Baxter Academy - Final Traffic Academy

Hi Shukria – I have reviewed the application materials and offer the following final traffic comments.

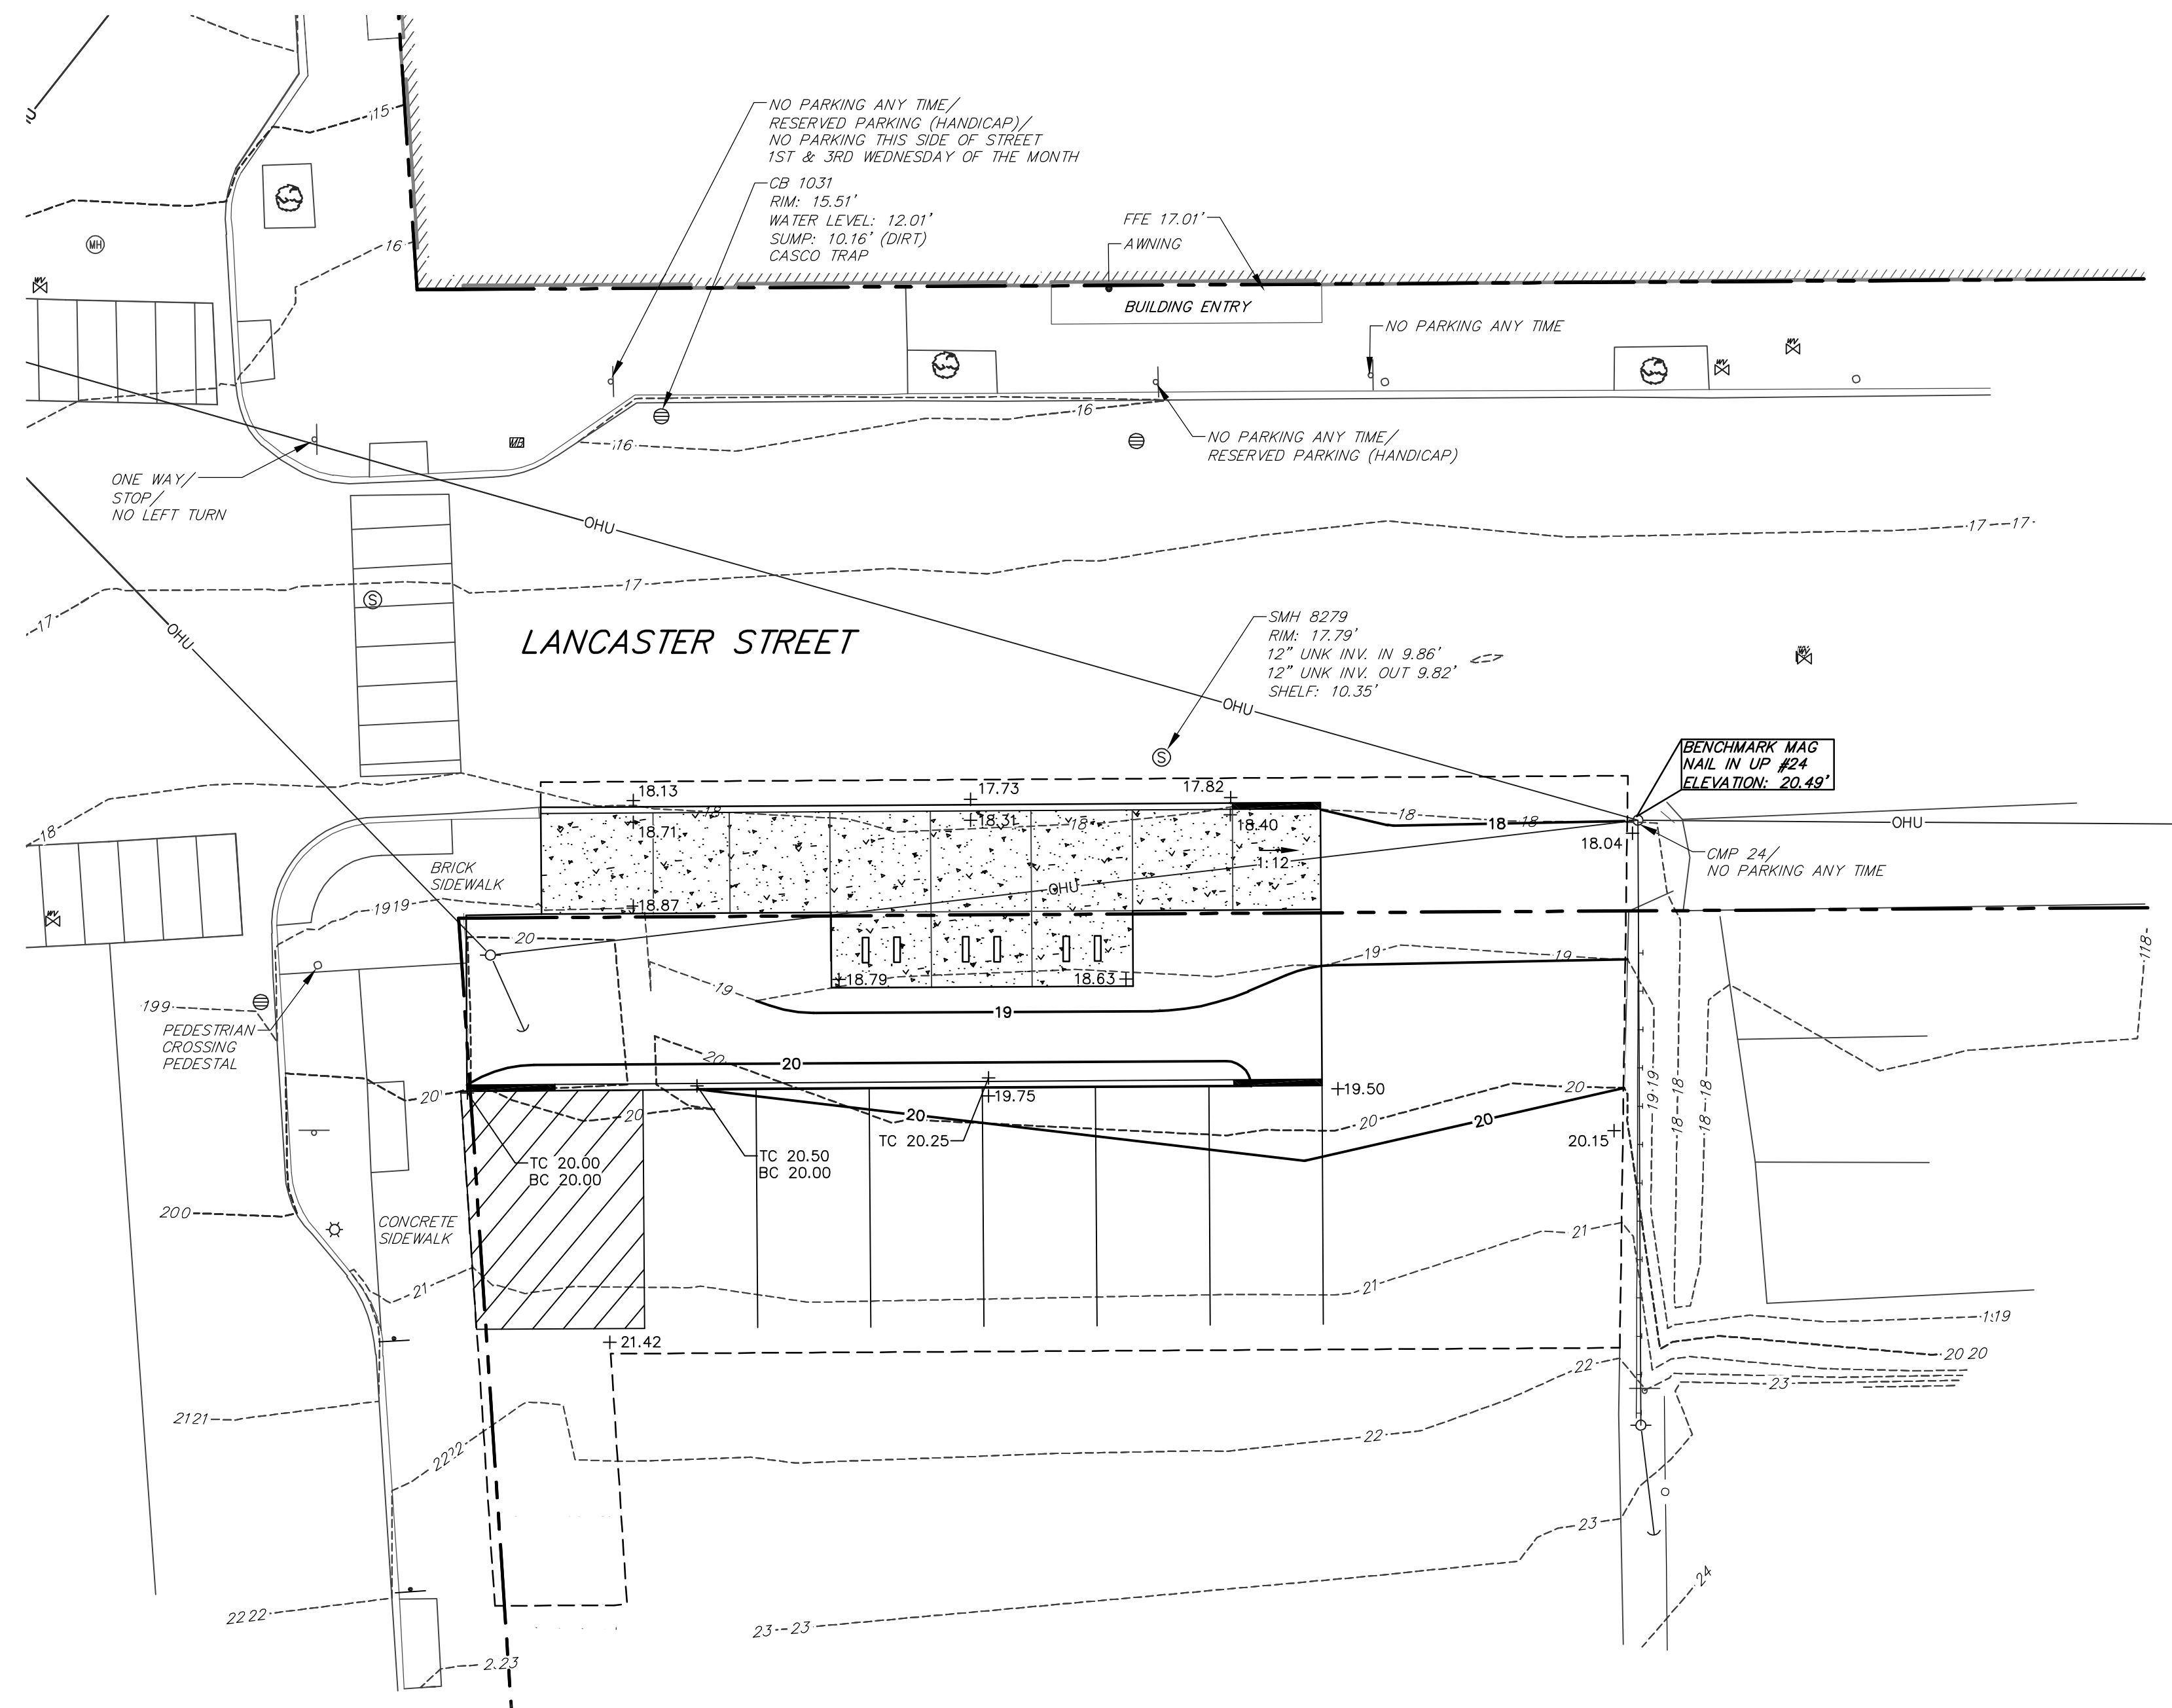
- I have reviewed the site plan and I generally find conditions to be acceptable. I would note that the specific on-street regulatory signage is not acceptable and details of parking restriction wording will be determined in conjunction of the City Parking Division.
